**WEST SUSSEX COUNTY COUNCIL
INFRASTRUCTURE CONSULTATION**

SUBJECT: WA/12/11-Single storey Pre-school

Land adj. to Walberton Village Hall, The Street, Walberton, West Sussex

Project
Walberton Pre-School
Walberton
 Drawing
Proposed Site Plan

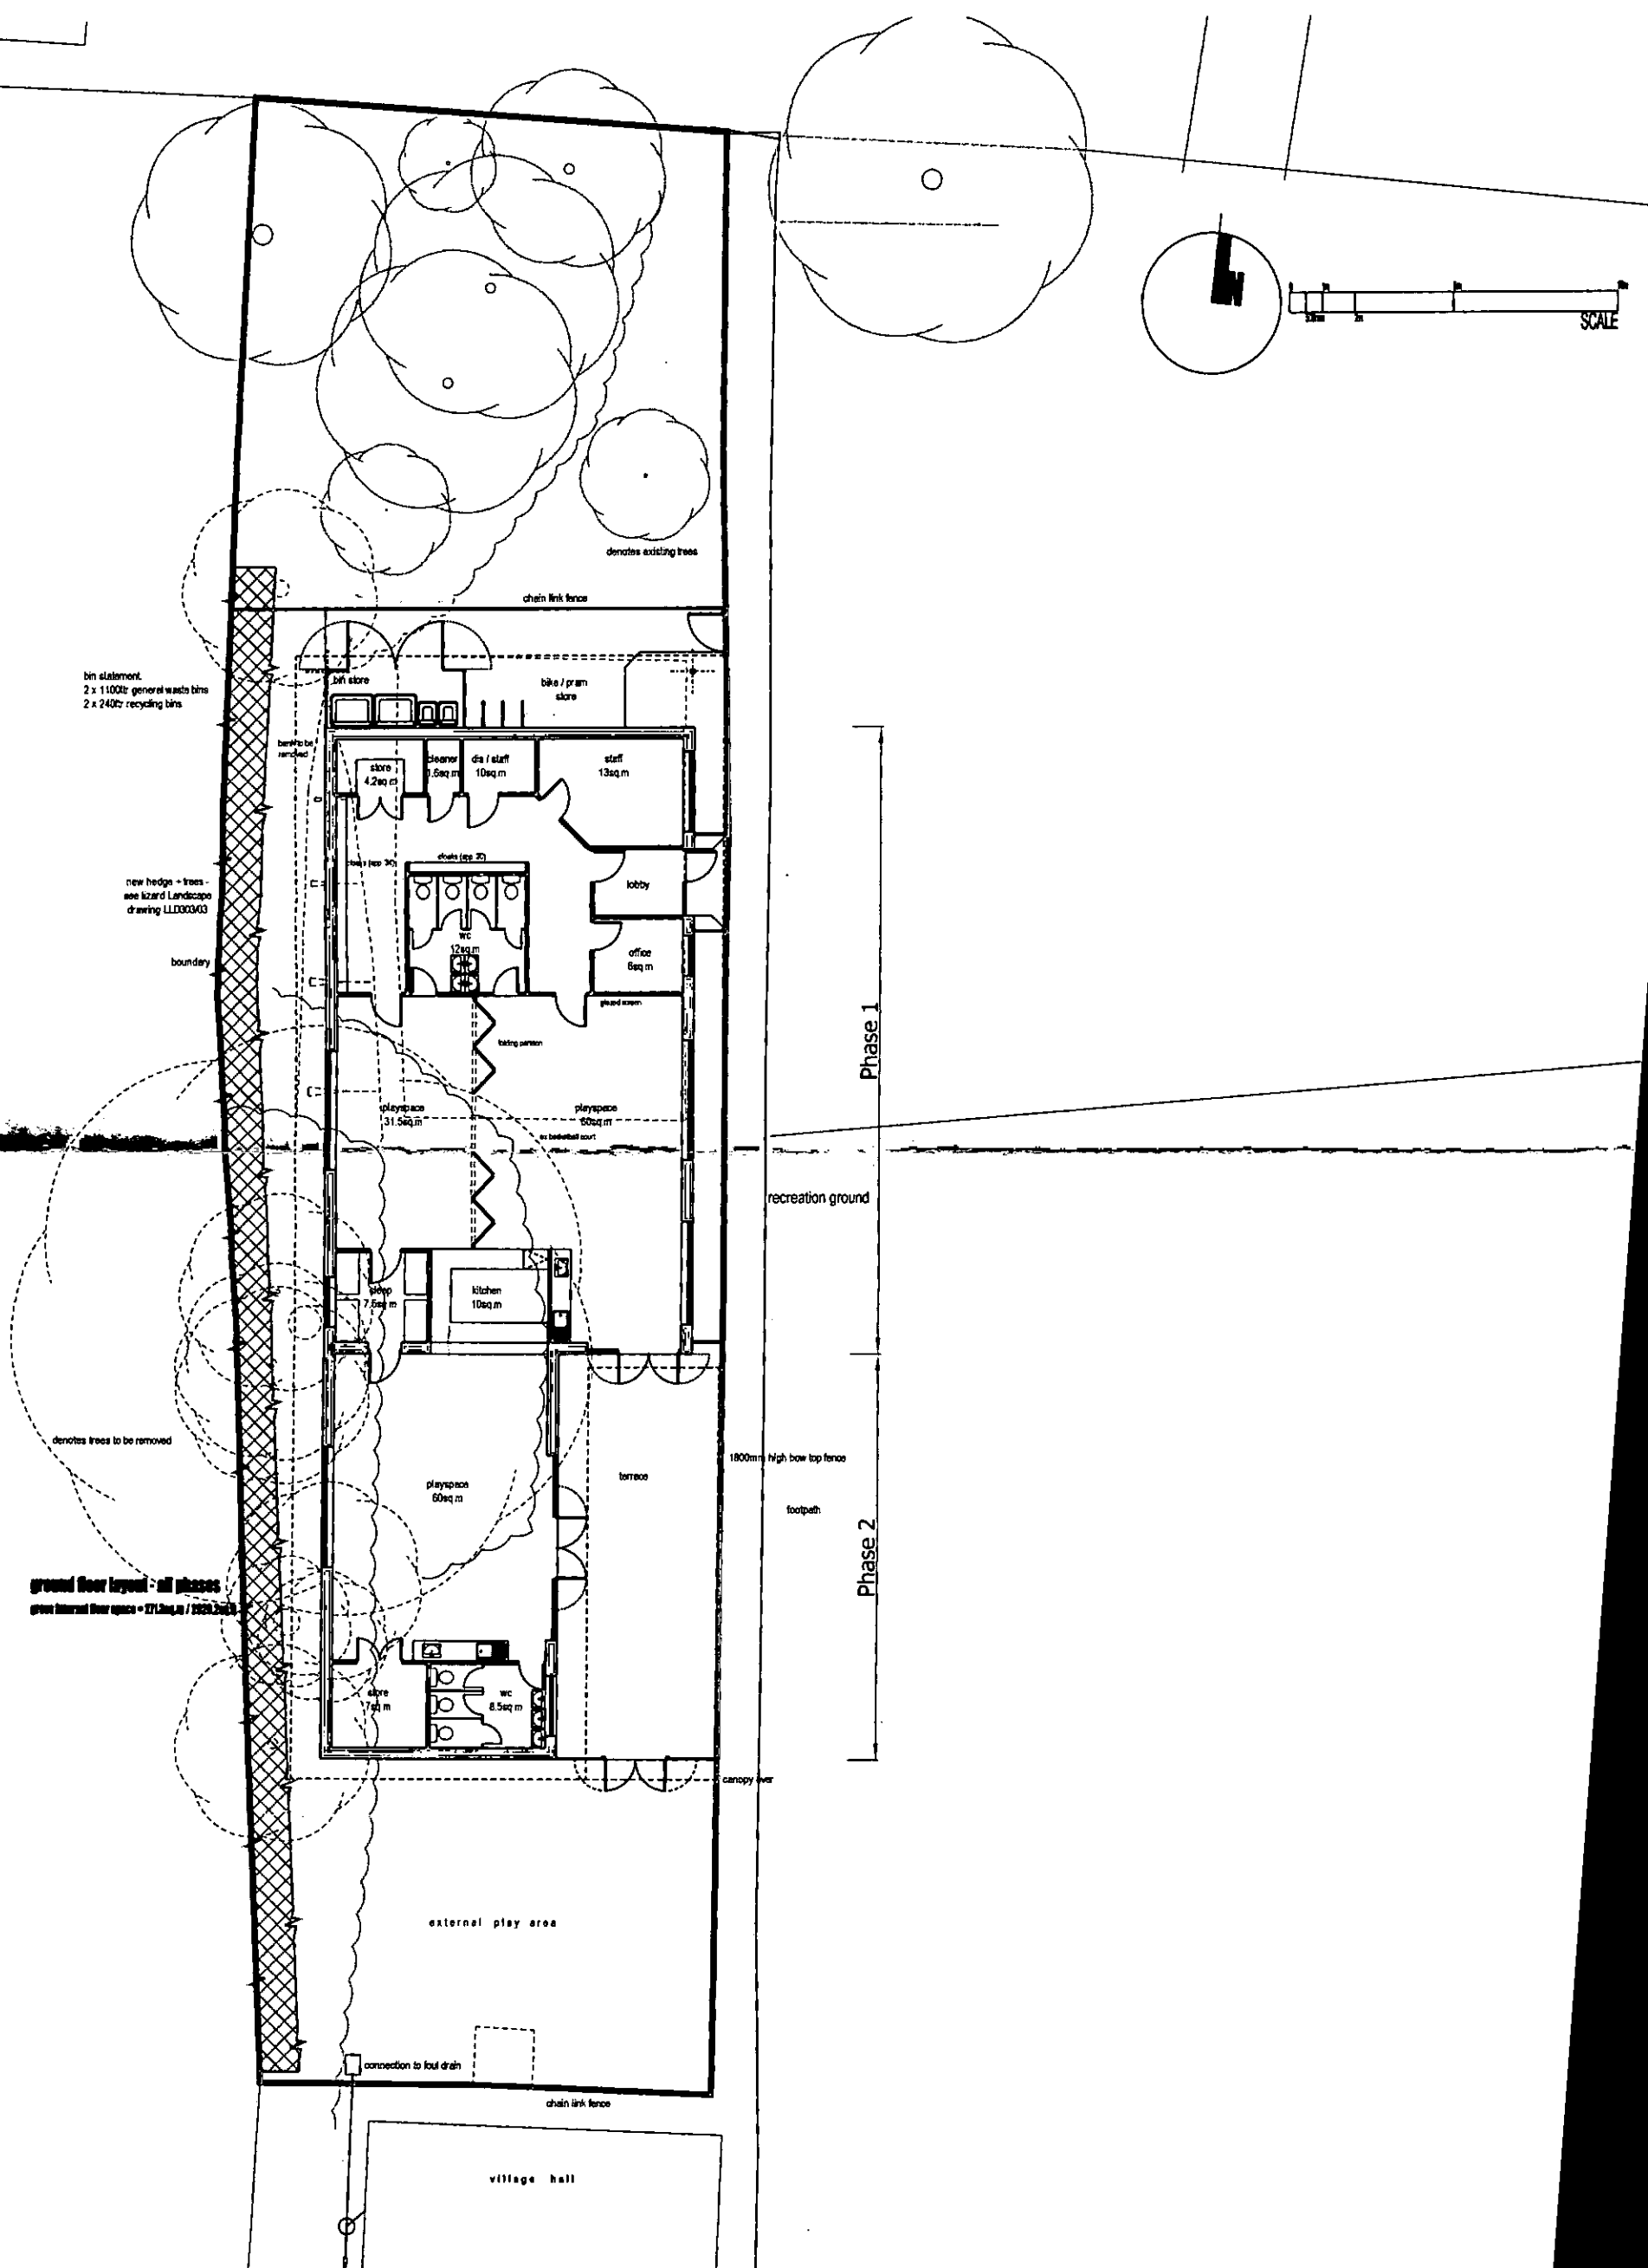
Further information would be requested on parking opportunities within the immediate vicinity. It is assumed the existing village hall car park will be utilised for dropping off of children. Further details of the pre-school arrival and departure times in comparison with the junior school in order for us to be satisfied the combined usage will not result in congestion with nearby main road through the village.

In order to obtain this information a Parking Capacity Survey should be conducted, this would need the applicant to demonstrate that the total number of parking spaces available, either through provision of off-street parking spaces, on-street spaces (on or off the public highway) or a combination of both, is sufficient to accommodate the expected number of vehicles at the proposal. If some or all vehicles are expected to park on the public highway, then the applicant will need to demonstrate, using a car parking capacity survey, that there is sufficient available space to accommodate the expected number of vehicles. Guidance on the County Council's approach to residential parking and car parking capacity surveys can be found on our website.

In addition the applicant will need to submit a Travel Plan which would need to include, details of the existing development, the proposed development, expected increase in vehicular activity, measures to encourage the use of transport needs other than private cars and public transport opportunities in the local area.

south elevation

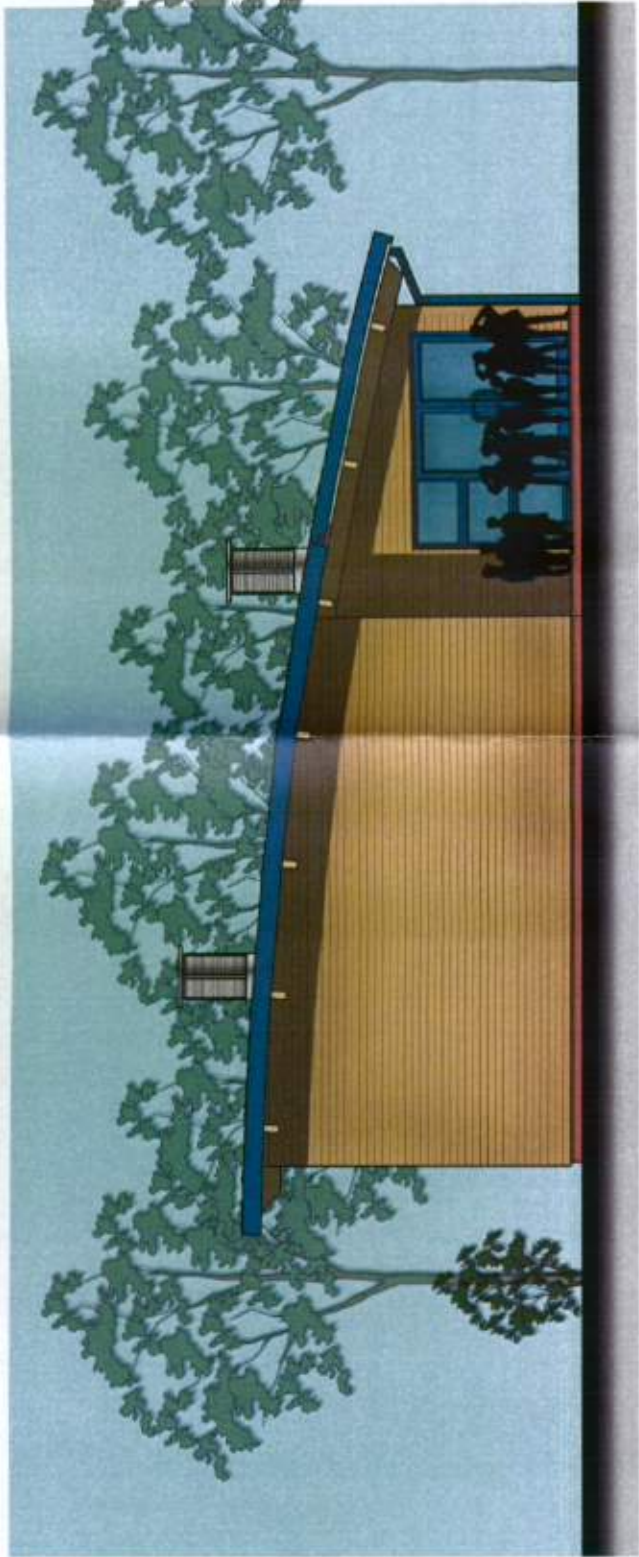
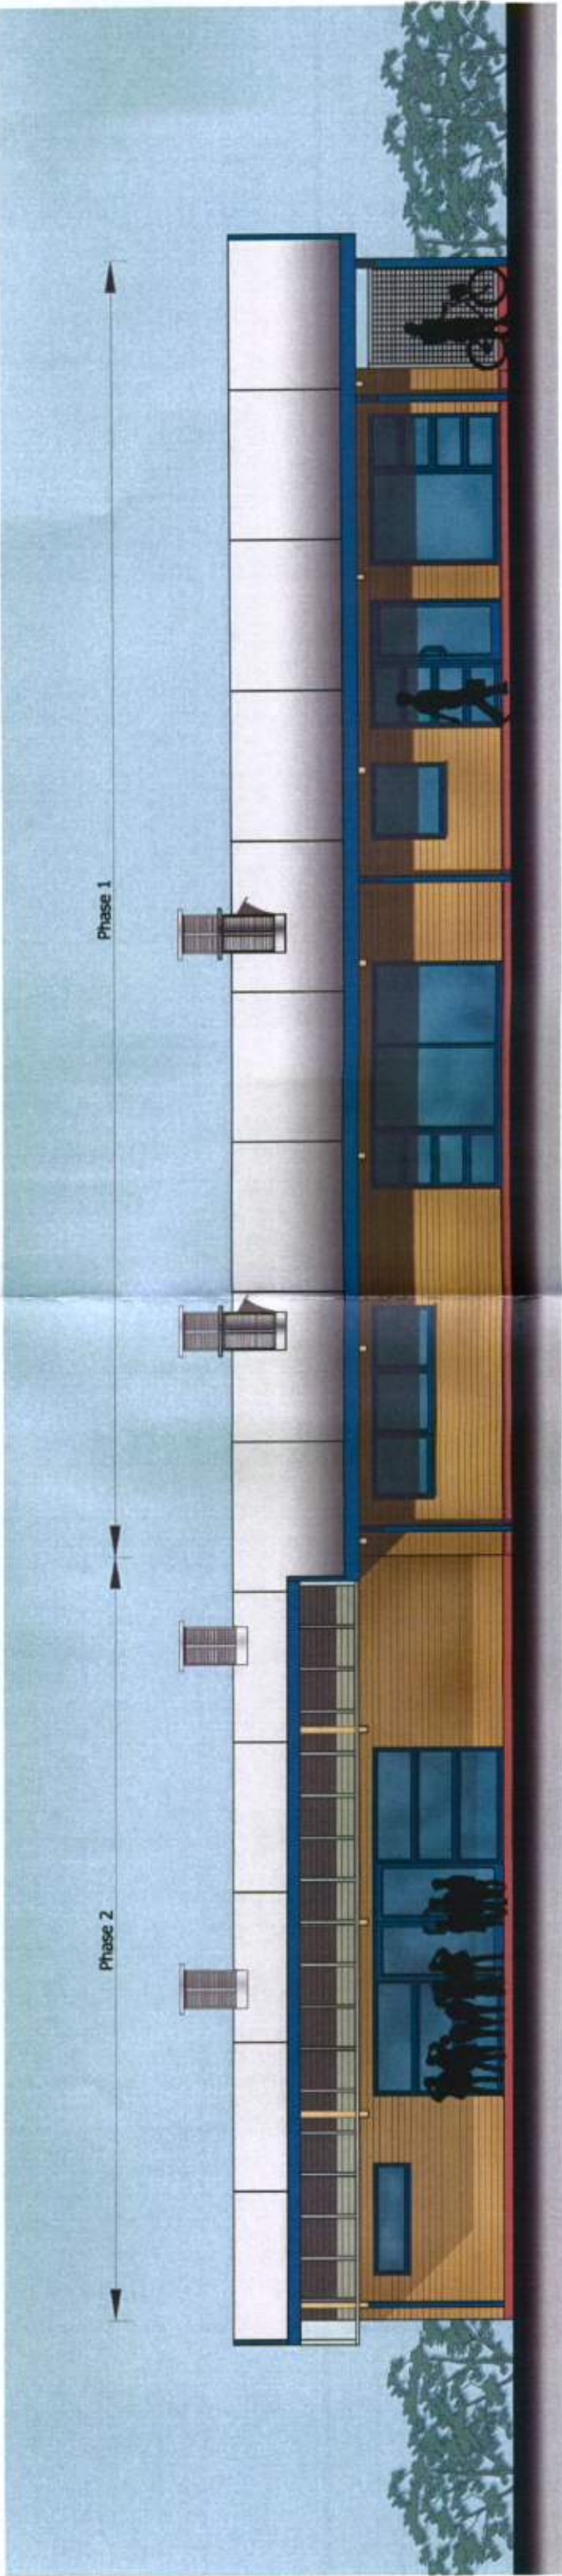
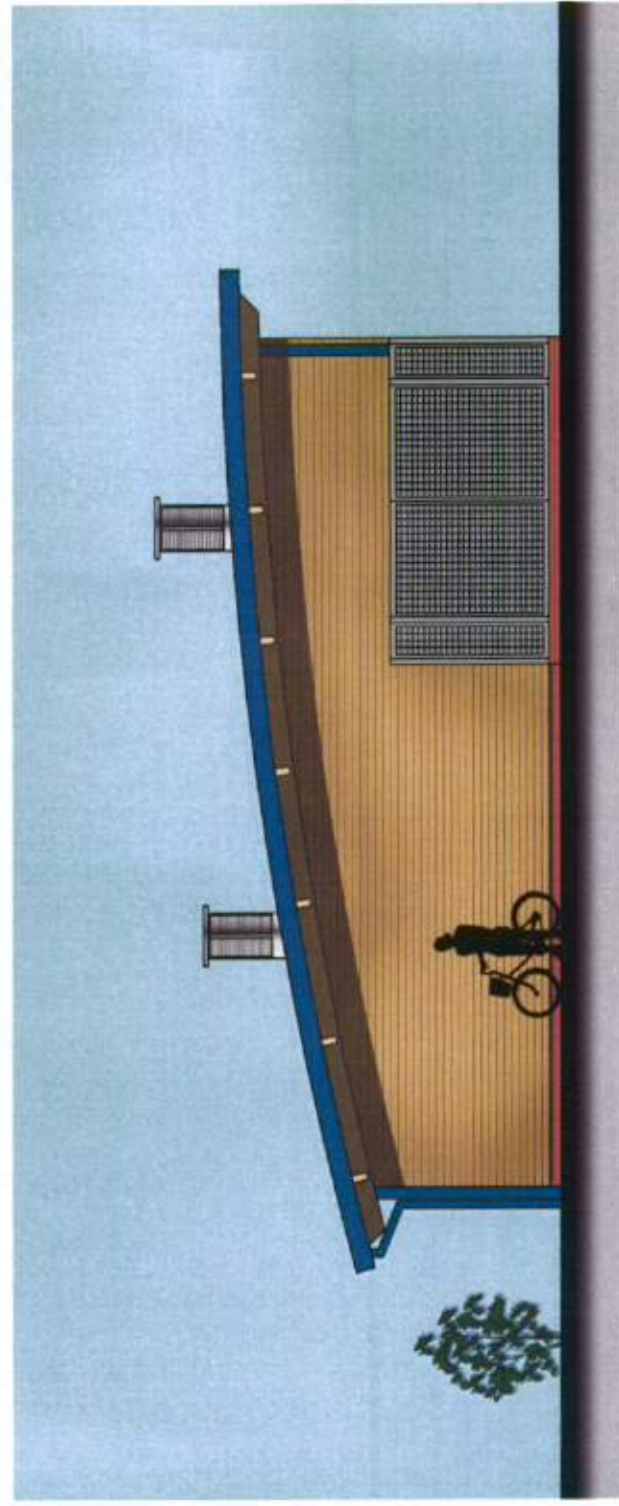
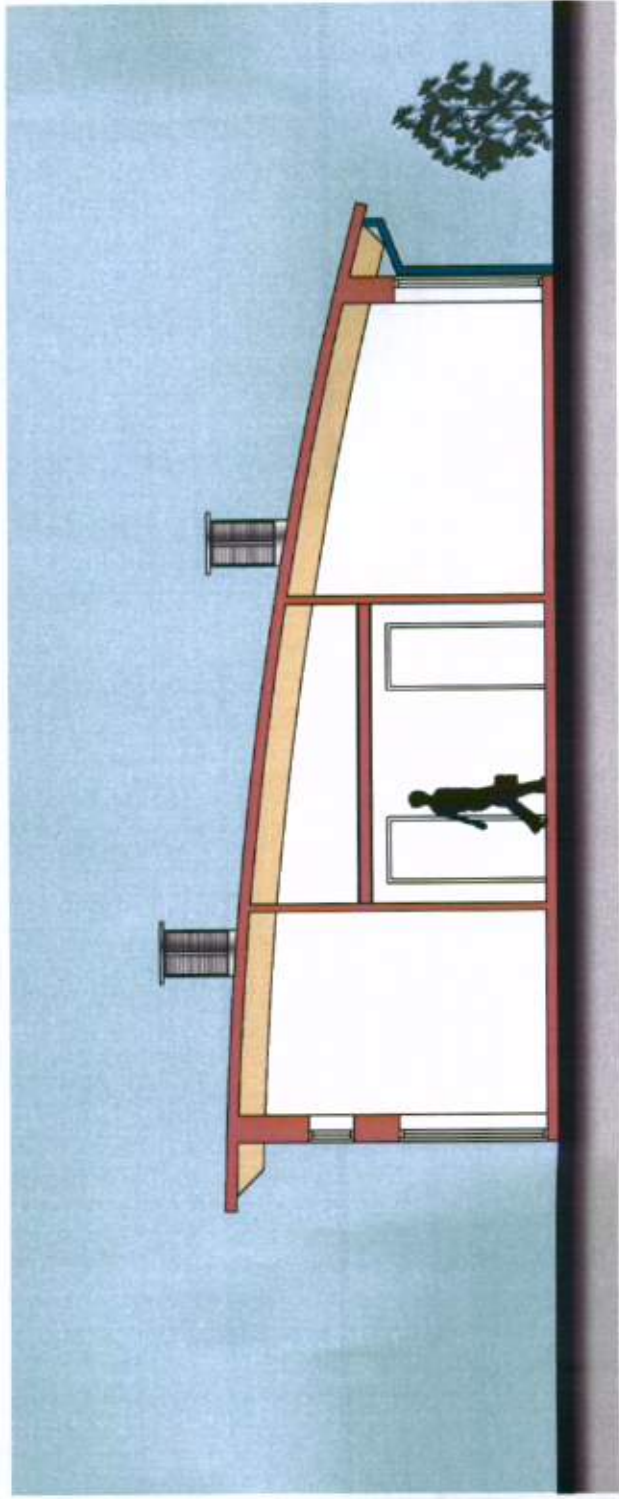
This proposal is a modern design that reflects its proposed use. It does not propose to reflect traditional architectural style in this locality. Its scale and position will not be problematic in this location.
